**Consultation Response from: KC Environmental Health (Pollution & Noise Control)**
**2024/92727 - Land adjacent to Ashbourne Drive, Liversedge**
**Erection of residential development 67 dwellings with associated access, parking, public open space, landscaping and infrastructure**
**Responding Date:**  
**25 November 2024**
**Responding Officers:**  
**MN, NH & SR**
**Responding Ref:**  
**WK202433245**
**Contaminated Land**

Drawing Title	Cross Sections		
Site	Ashbourne Drive, Cleckheaton		
Scale	1:1000 @A2	Date	19/09/24
Drawn	VB/MC	Checked	-
Drawing No.	Z168.007	Rev.	-
Thorpe Arch Grange Walton Road Thorp Arch LS23 7BA 01937 543599 www.newetthomes.co.uk

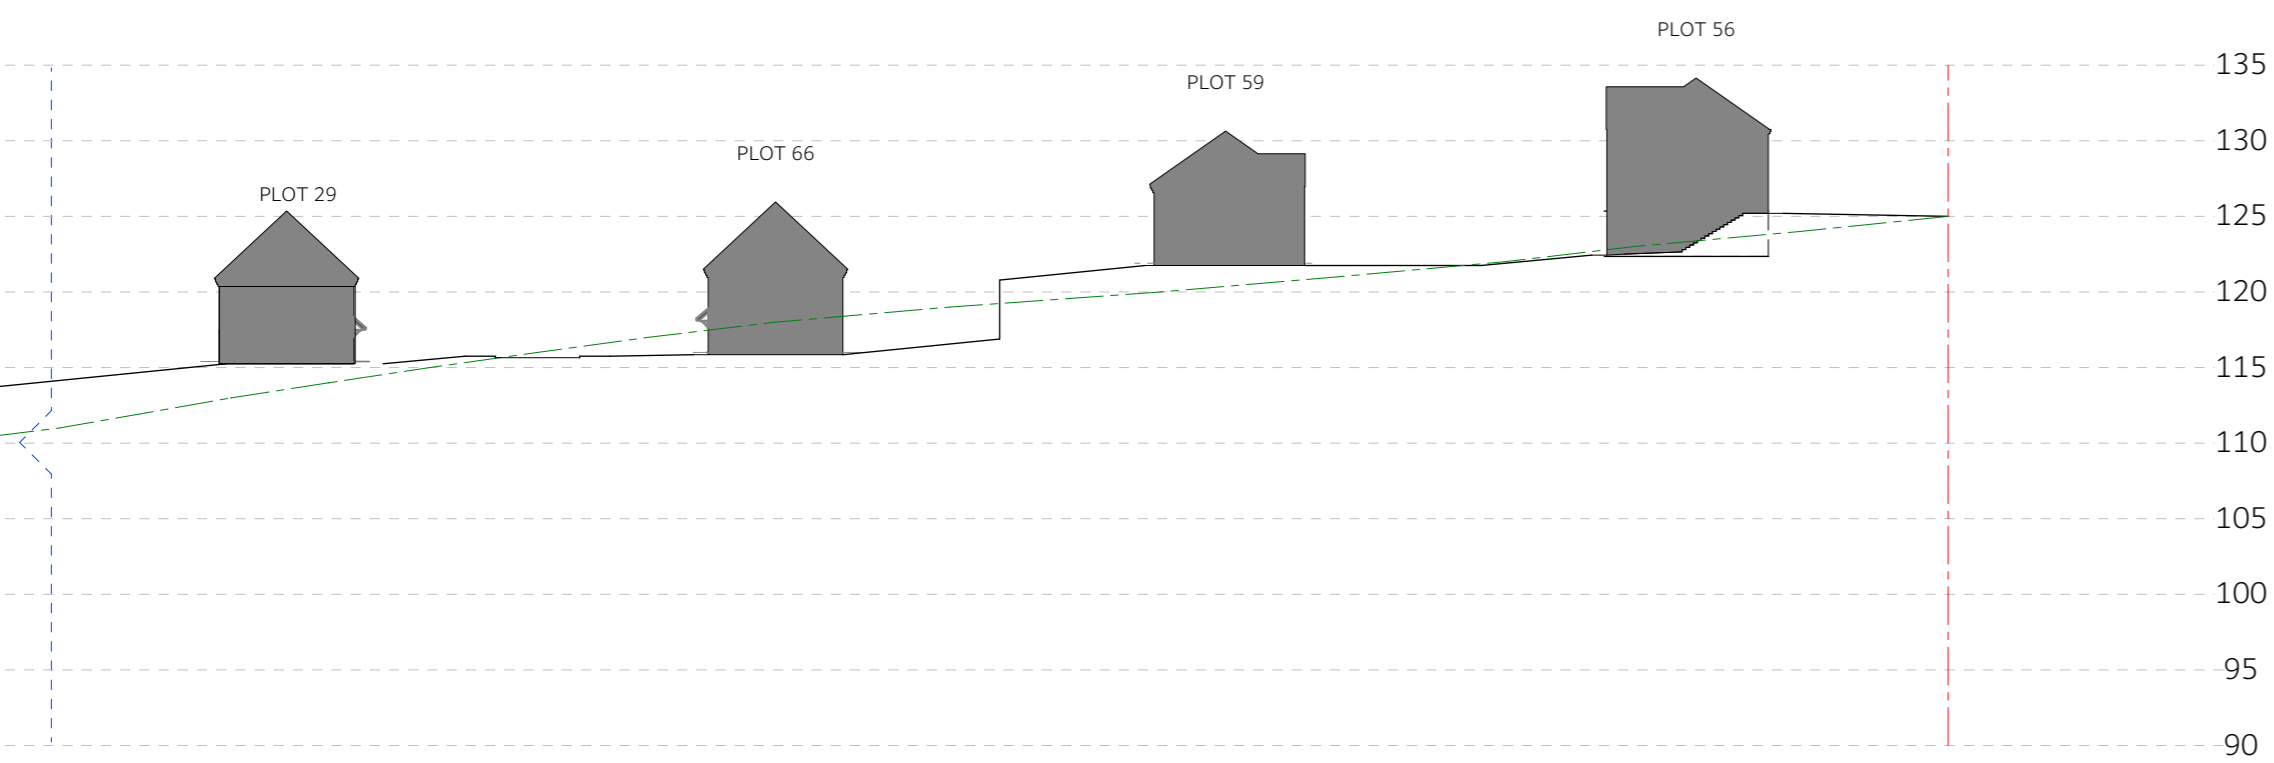
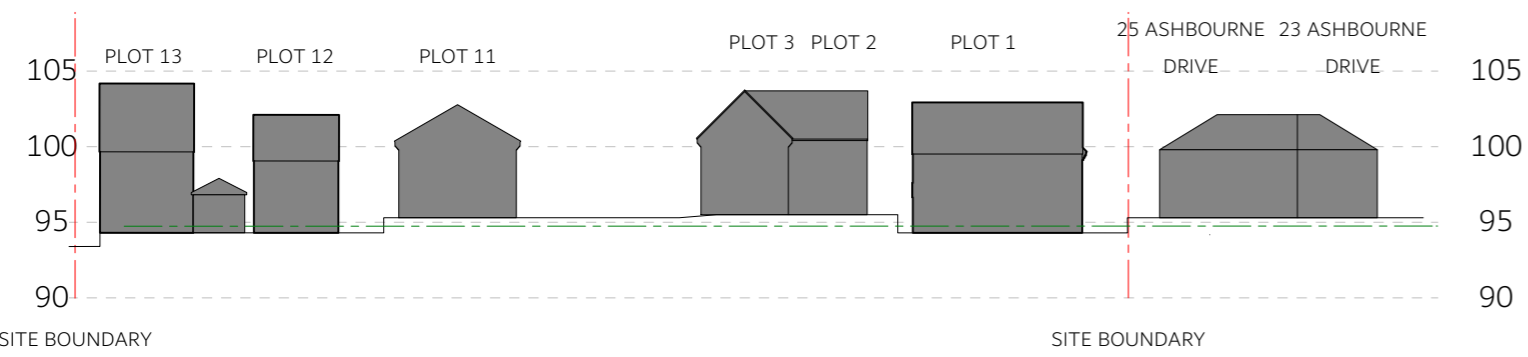
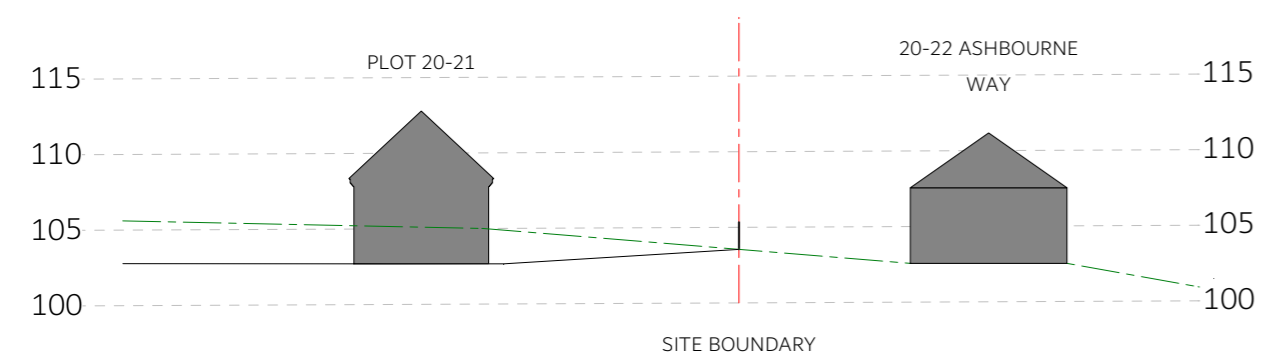
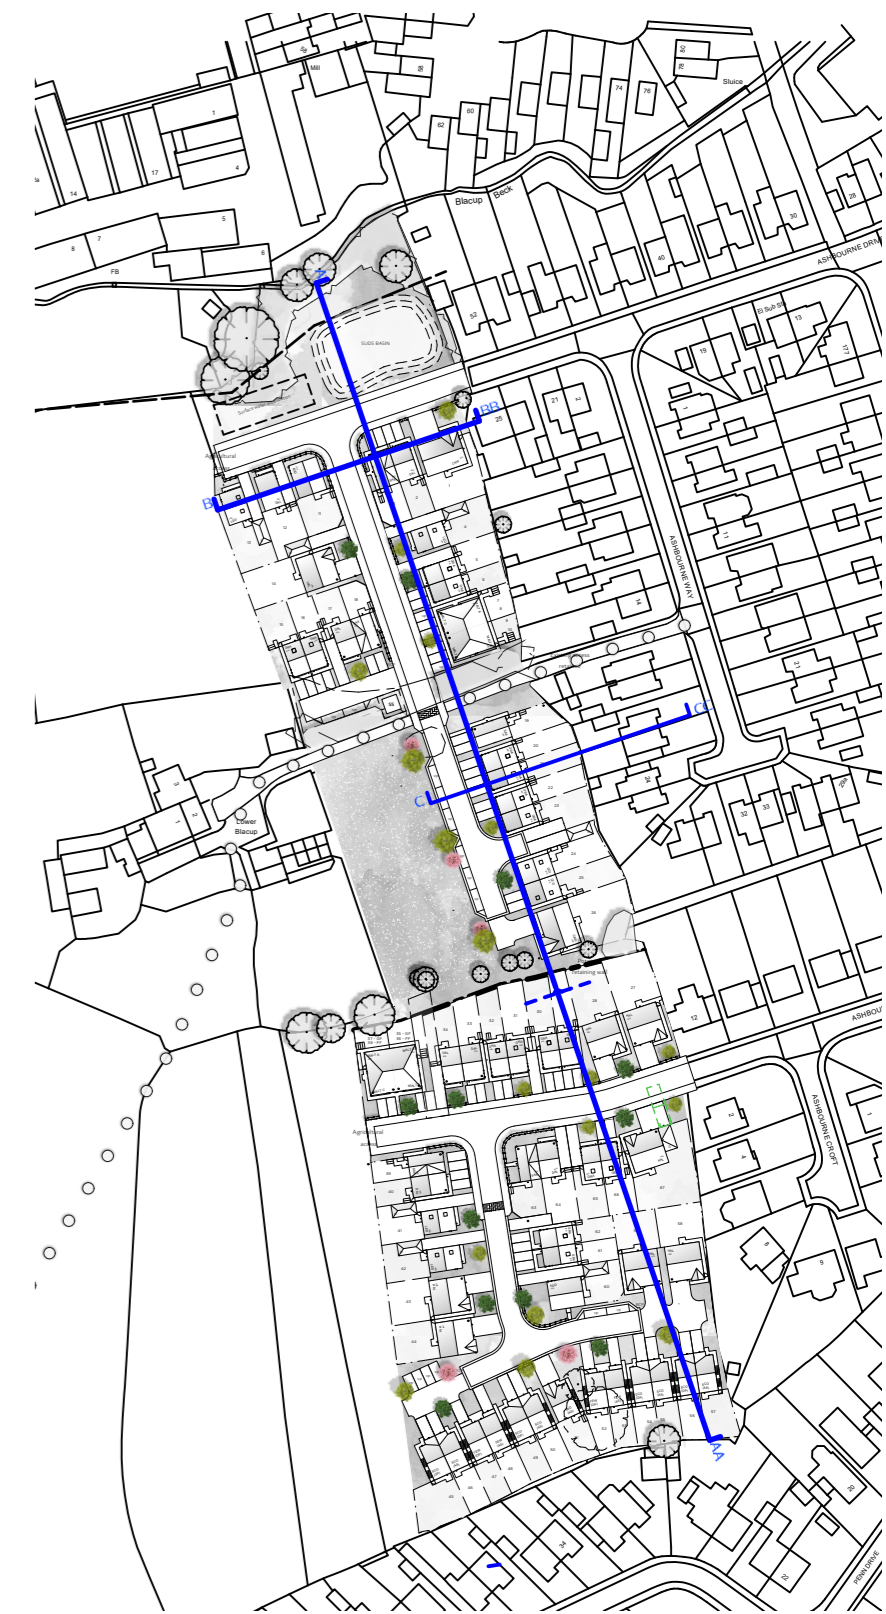
1. Could the applicant provide details of the proposed regrading plans? Considering the significant regrading and grouting described, we expect Lithos to reassess the ground gas risk, accordingly.
2. Clarification is requested regarding the range and trends of atmospheric pressures recorded during the ground gas monitoring visits, as this information remains unclear. We expect monitoring to be undertaken in accordance with good practice guidance.
3. We cannot support the reuse of materials or the placement of made ground beneath hardstanding without full brownfield suite testing, given the sensitive end use and the amount of heterogenous made ground on site. Either further testing or additional justification is necessary to increase confidence in the current risk assessment.

Given these points, we recommend conditions to secure a detailed remediation strategy for the site and to ensure appropriate land contamination management throughout subsequent development phases.
